**From:** Laura Gibbons  
**Sent:** 11 April 2019 12:59  
**To:** Planning.Responses  
**Cc:** Anita Gardner  
**Subject:** RE: Planning Consultation on LU/109/19/DOC

Engineers Comments Regarding Condition 3 and 4

**APPLICATION**                      **LU/109/19/DOC**

**Site Address:**                      Shell Eastfield Worthing Road Littlehampton BN17 6LE

Typical Permavoid Geo-cellular Attenuation System with Permeable Paving and Granular sub-base Detail (Mh S12)

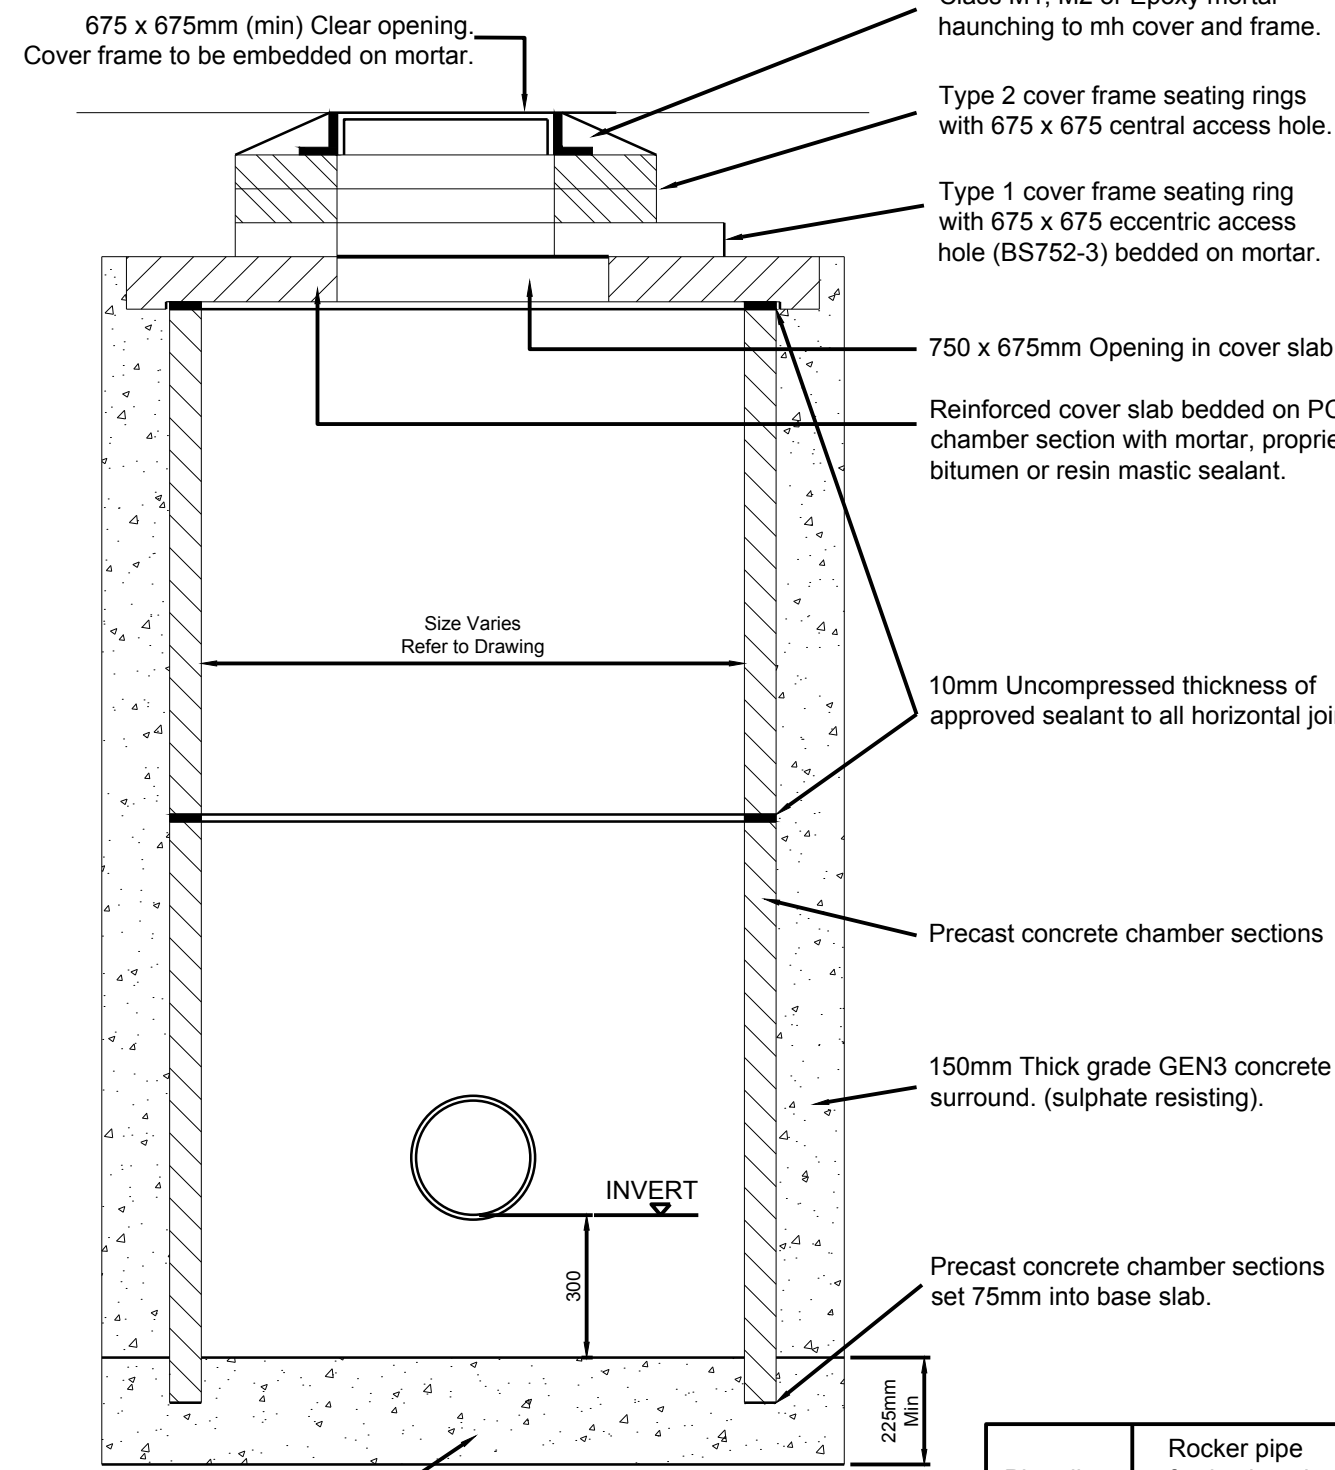
3. The layout plan provided is unclear in terms of differentiation of the two networks. Please revise line types etc.
4. Catchpit manholes should be provided upstream of attenuation tanks.
